Project Title: Water Lane, Angmering

Project No/ Document Reference: A290-TN001

DRAINAGE – HOLDING OBJECTION

Further to your email, in response to our clients reserved matters and discharge of conditions application, please find below further information regarding your comments from Laura Gibbons, Engineer, on behalf of Adur & Worthing Councils. This response refers to Application Reference A/109/20/RES. We also refer you to the idom merebrook, Flood Risk Assessment, Ref: FRA-19495-16-139 Rev R2 approved at outline planning (A/99/17/OUT) and which we adhere to throughout.

Scale	Date	Drawn	Checked
1:500 @ A1	MAY 20	SM	SL
Drawing No	Revision		
A290-RM-402	P2

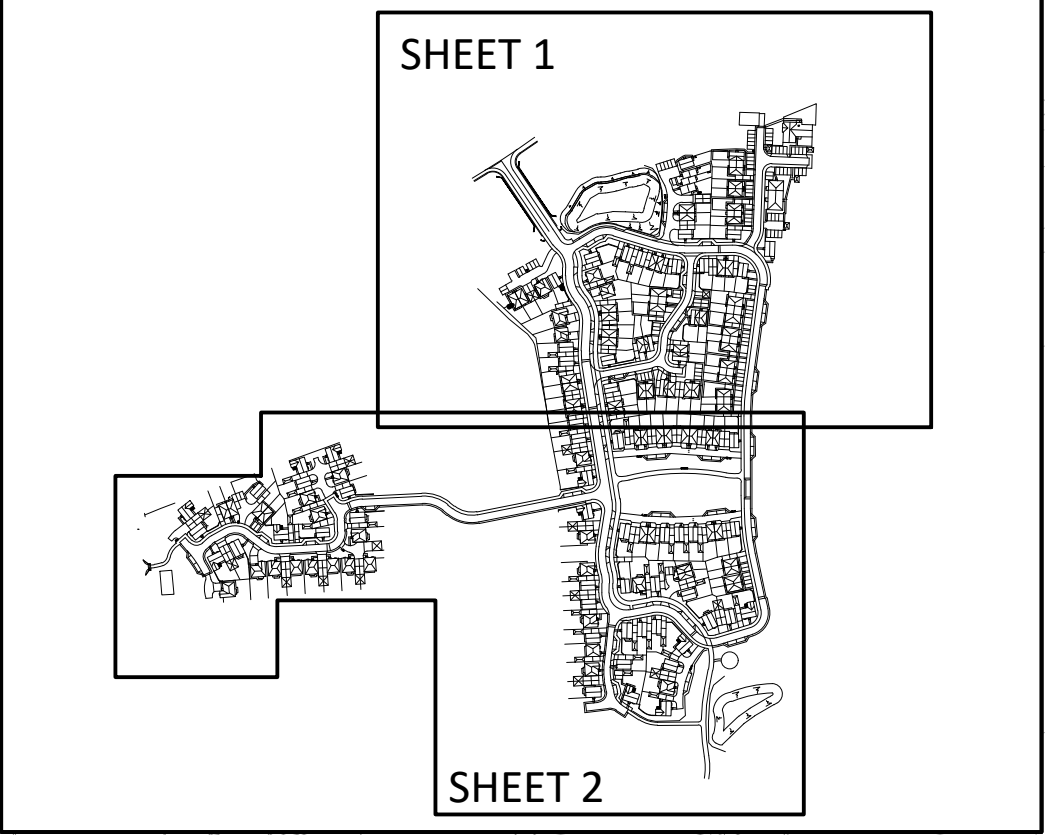
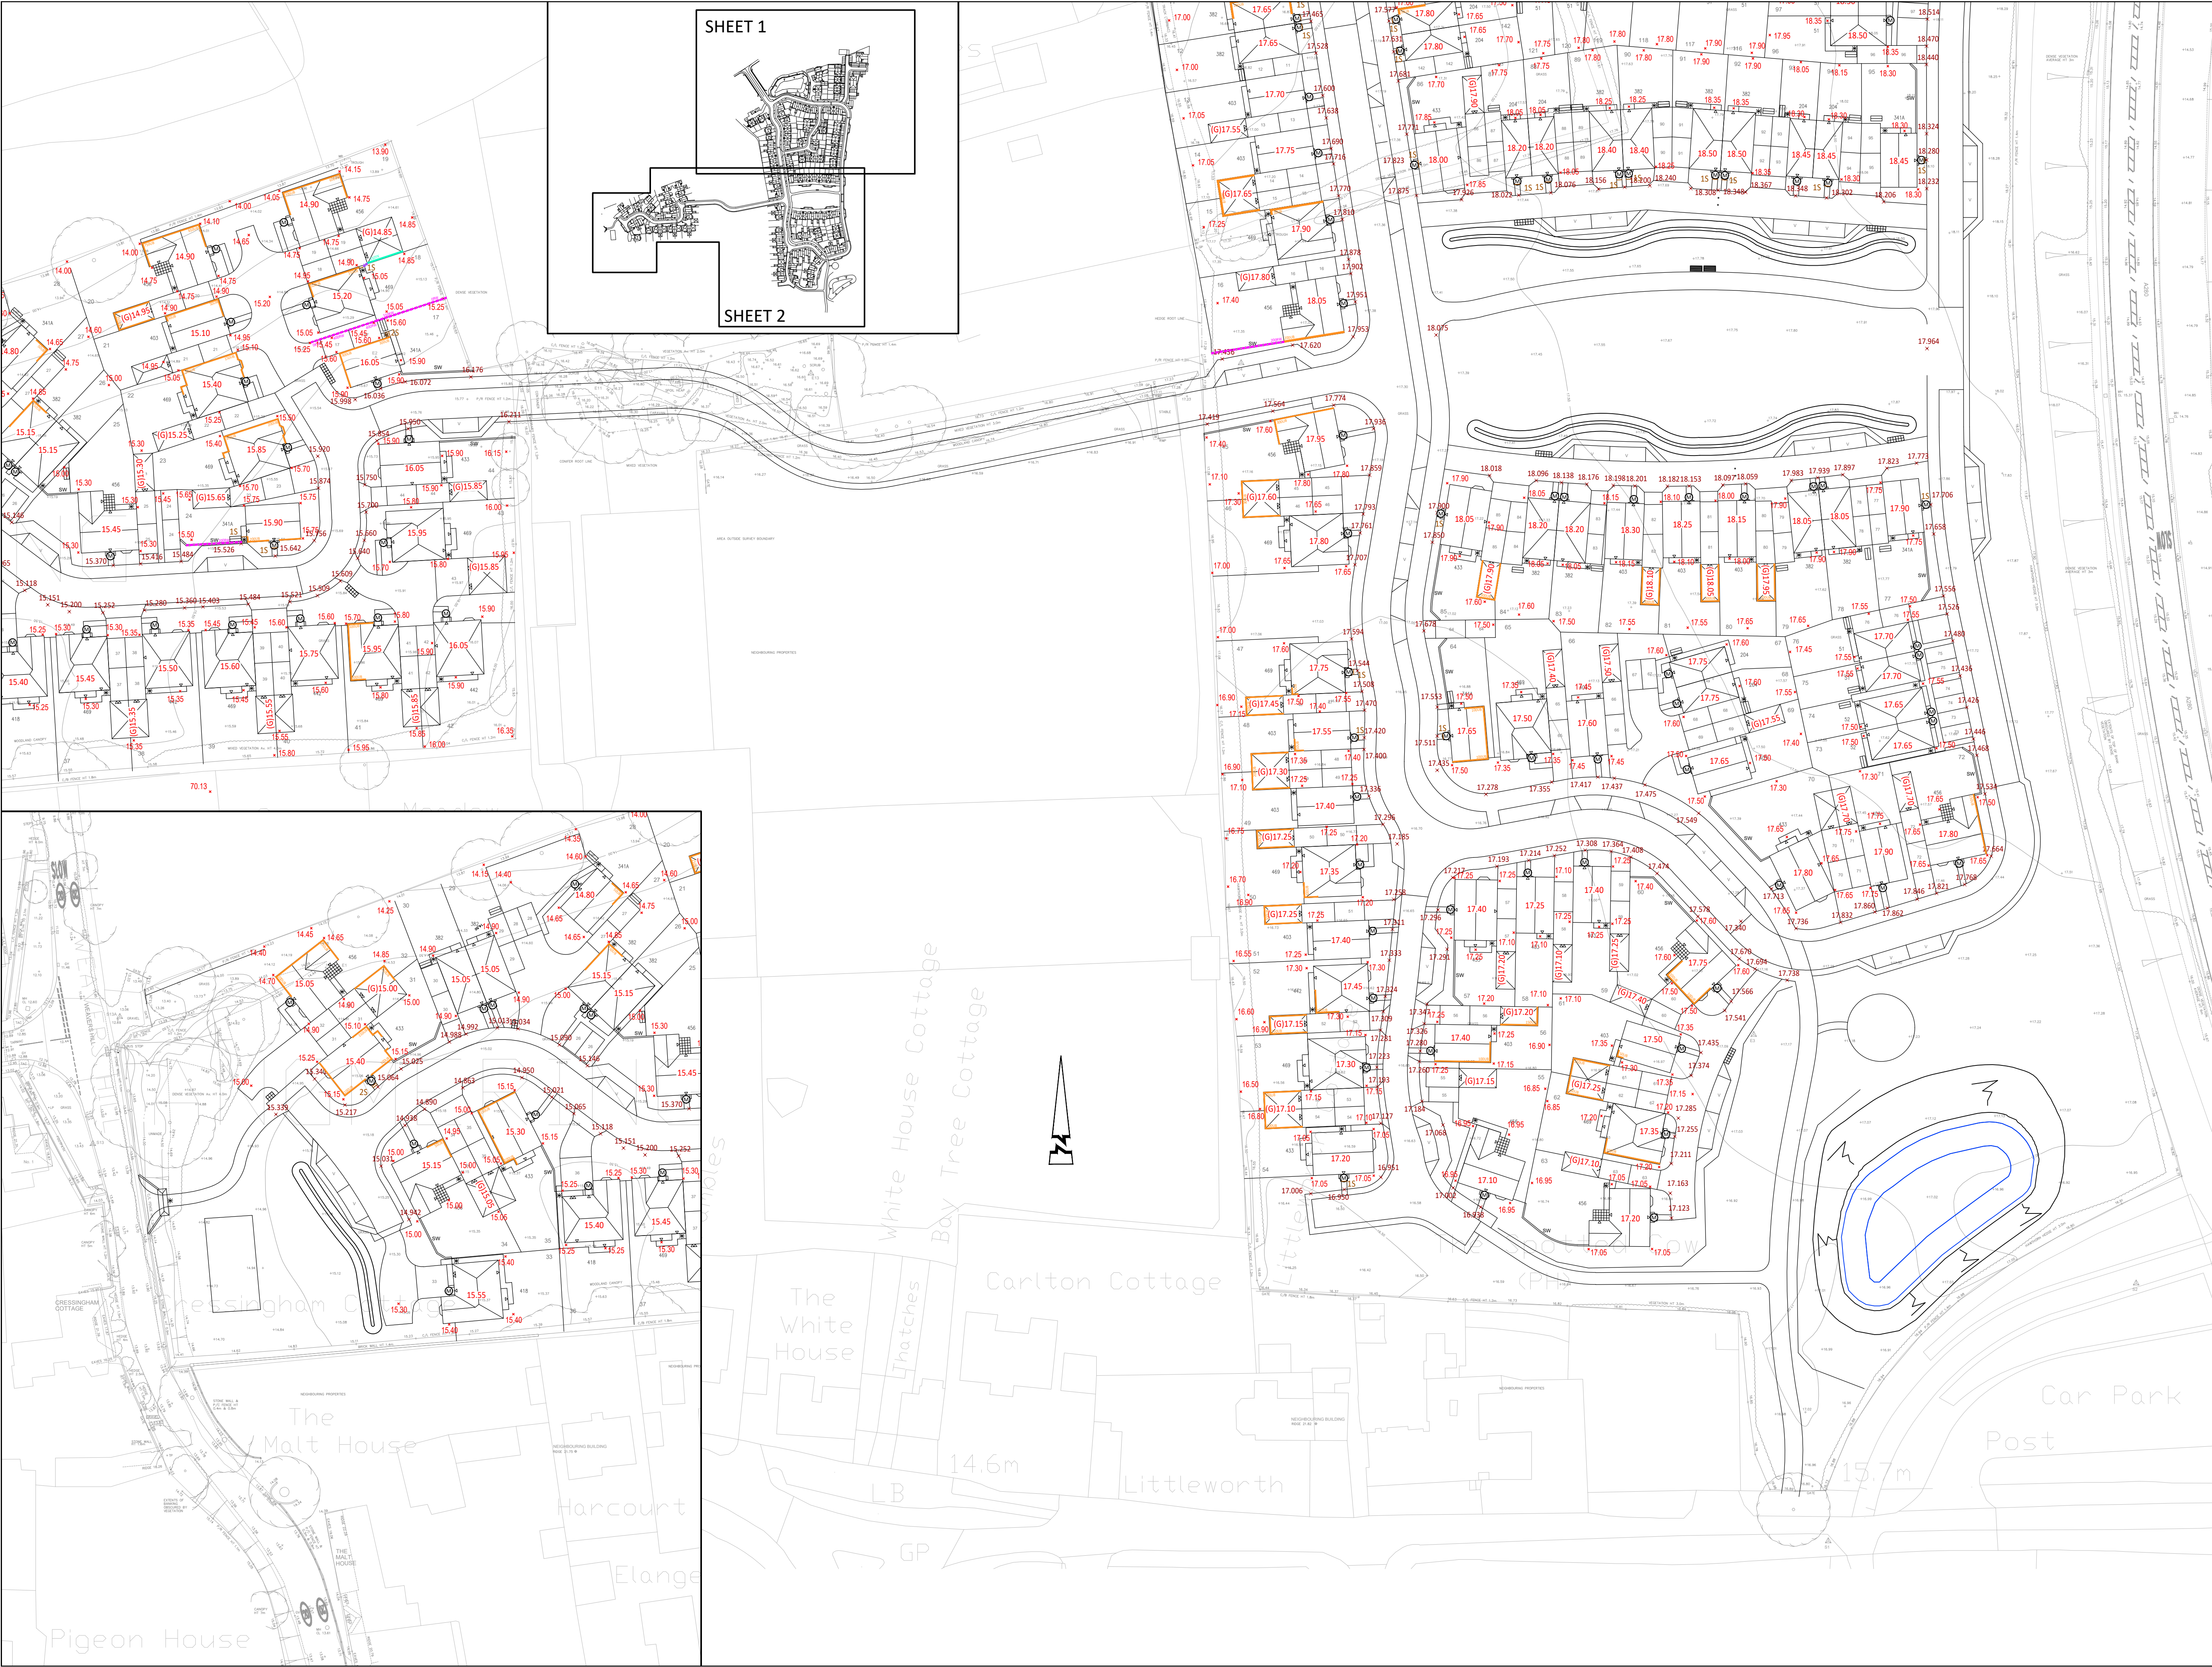
A plan showing proposed levels and catchments must be provided.

Layout plans with main river predicted flood extents shown must be supplied to evidence that the basin is located outside of predicted flooding extents.

Drawing's A290-RM-401 P2 and 402 P2, Engineering Layouts Sheets 1 and 2, submitted with the RM submission provides all proposed site levels. Drawing's A290-RM-501 P2 and 502 P2, Drainage Layouts Sheets 1 and 2, submitted with the RM submission provides all proposed drainage levels. There are also numerous other drawings relating to levels and drainage.

Drawing's A290-RM-401 P2 and 402 P2, Engineering Layouts Sheets 1 and 2, submitted with the RM submission provides all proposed site levels. Drawing's A290-RM-501 P2 and 502 P2, Drainage Layouts Sheets 1 and 2, submitted with the RM submission provides all proposed drainage levels.

These drawings clearly show all development to be way in excess of the approved flood levels, including, the basin which has proposed and existing levels on it.
